Update 16/08/2026

Further to the additional documentation submitted by Bellway regarding the Planning Application 2025/93355 (land off Woodward Court) I wish to make the following comments.

Ref Application 2025/93355

EXISTING 30MPH SPEED LIMIT ON HEPWORTH LANE BUT SEE NOTE 2 FOR ACTUAL SPEEDS

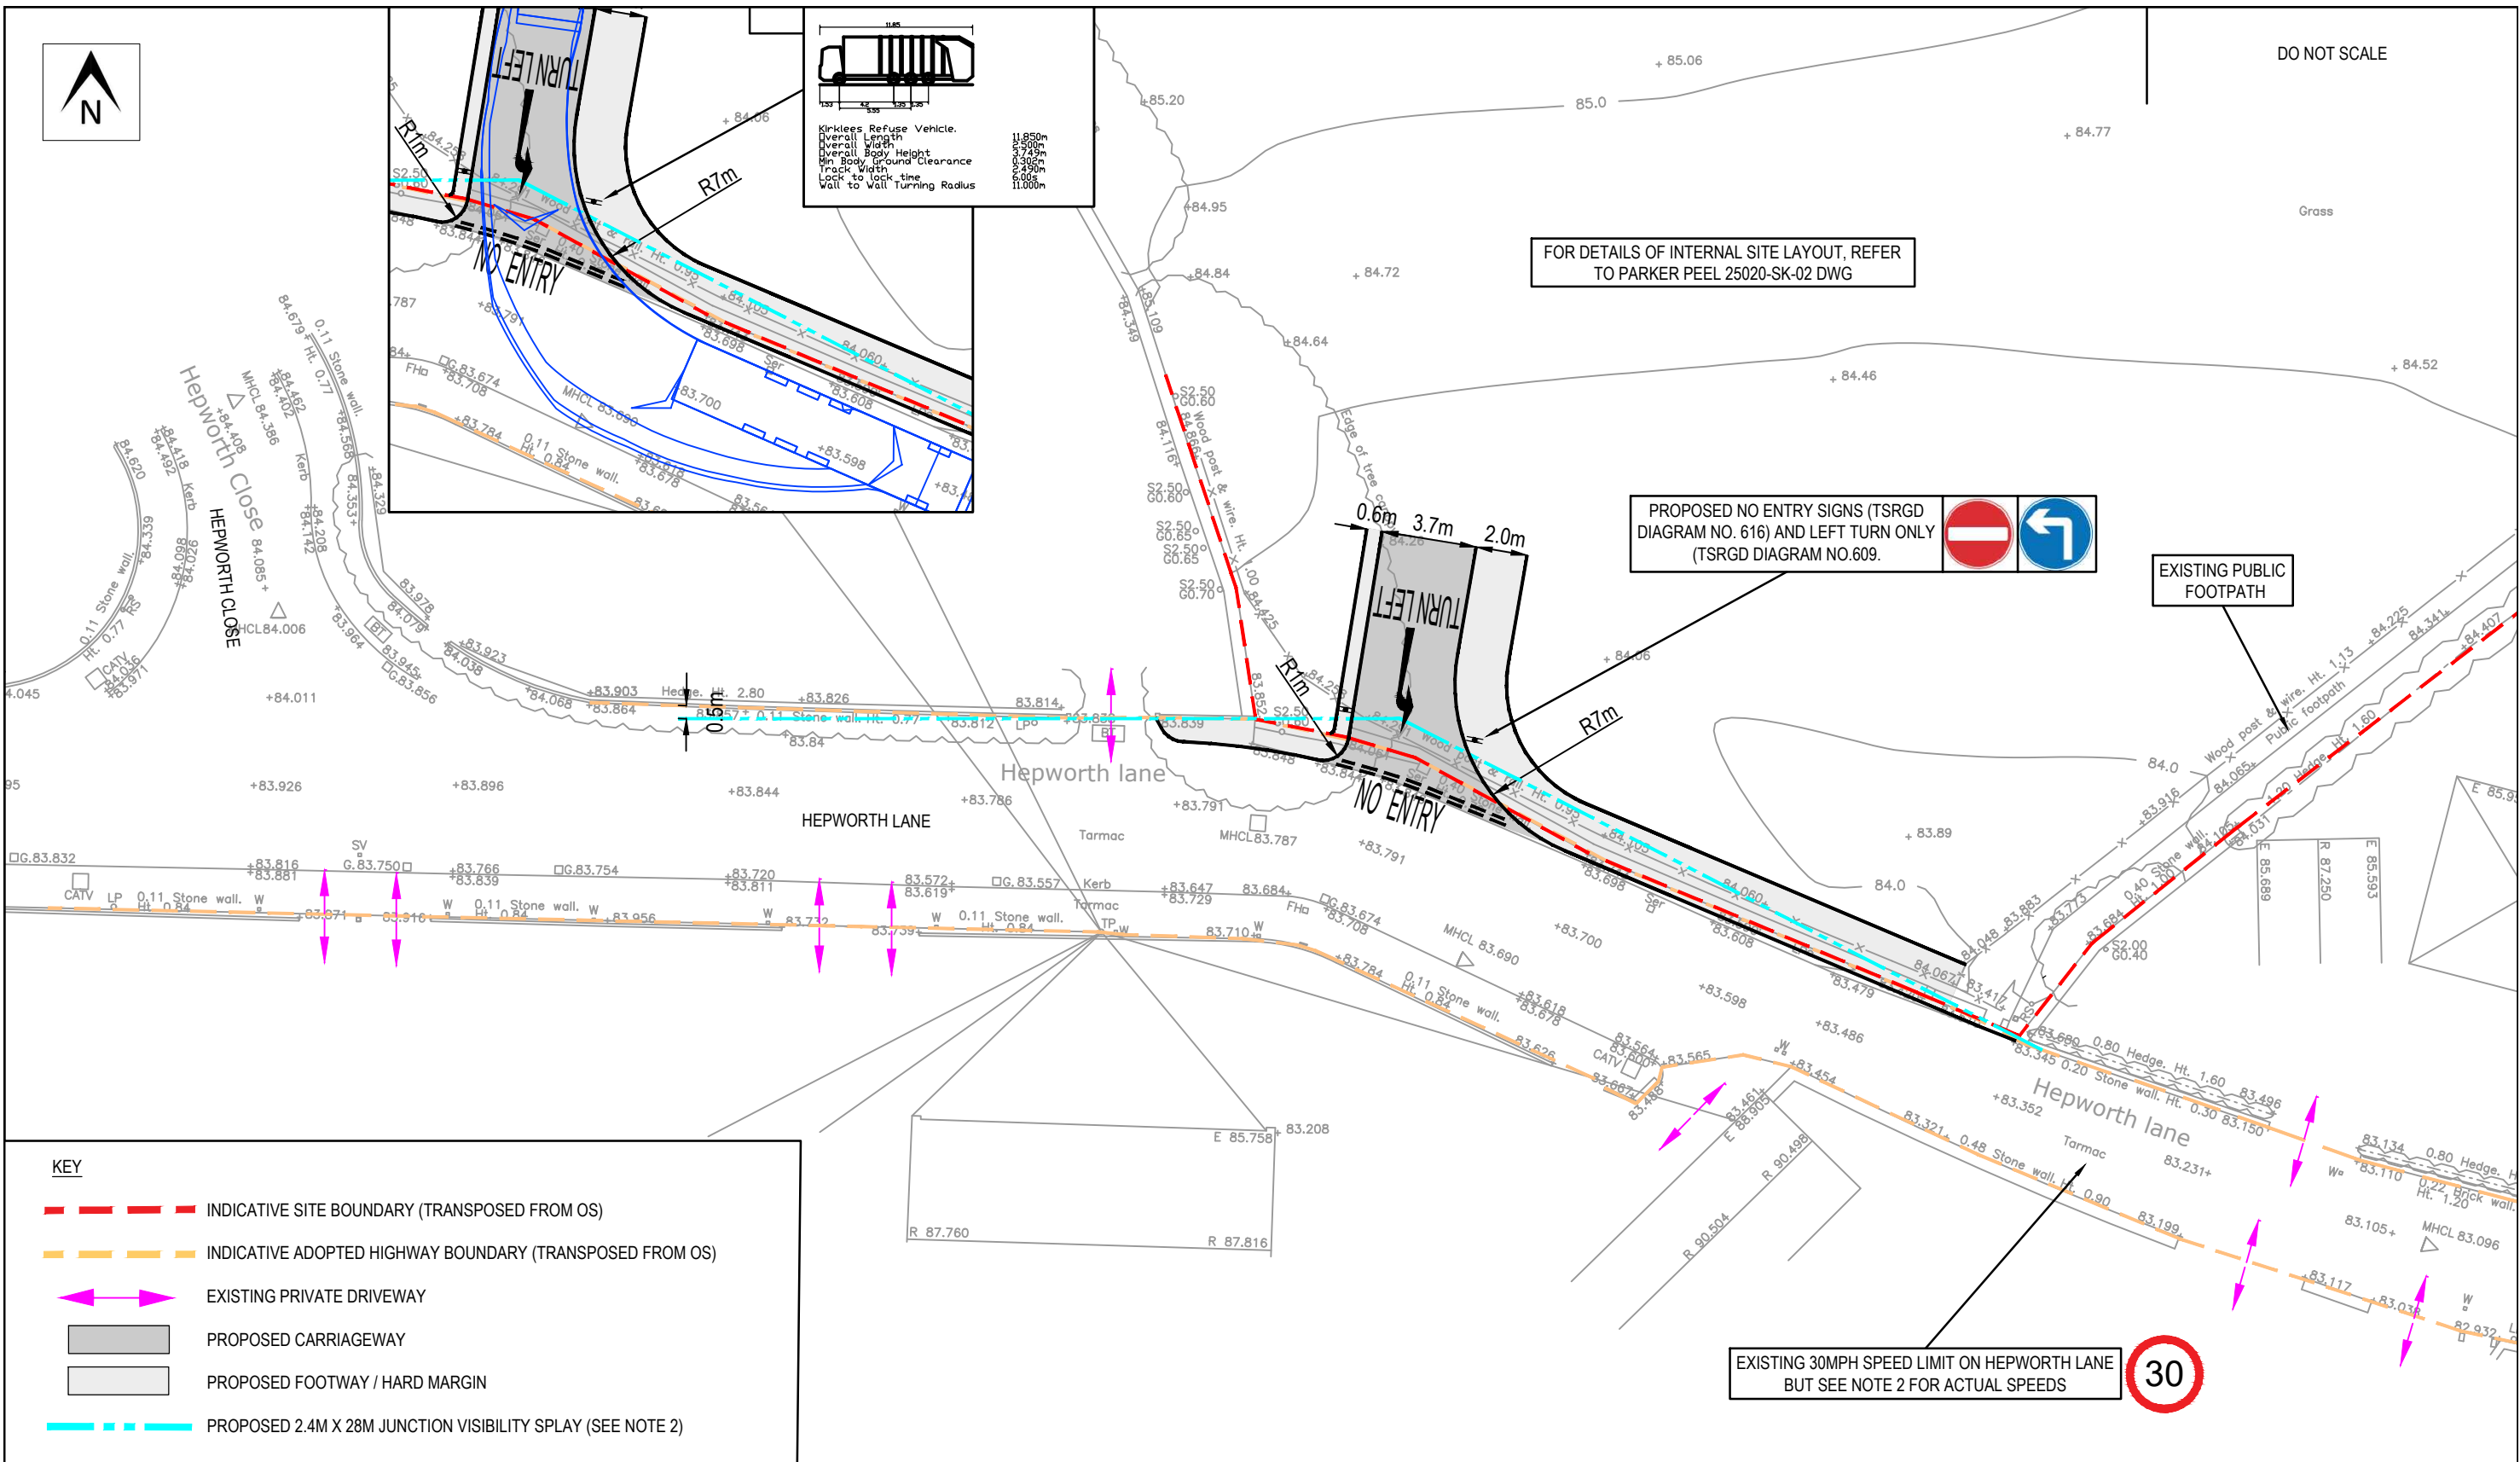
Making the exit from the development into Hepworth Lane exit only will not address the original issue that is that vehicle exiting the development will not be able to see vehicle approaching from the left until they are within approx. 30m making this exit completely unsafe.

- a) The exit from the development onto Hepworth Lane is unsafe. Hepworth Lane in this area is only wide enough for one vehicle and there is no pavement. Hepworth Lane is well used by pedestrians especially children walking to and from school.
Also traffic turning from the Development into Hepworth Lane will find it difficult to see clearly what (vehicle or pedestrians) are approaching from the East due to the curvature of the road.
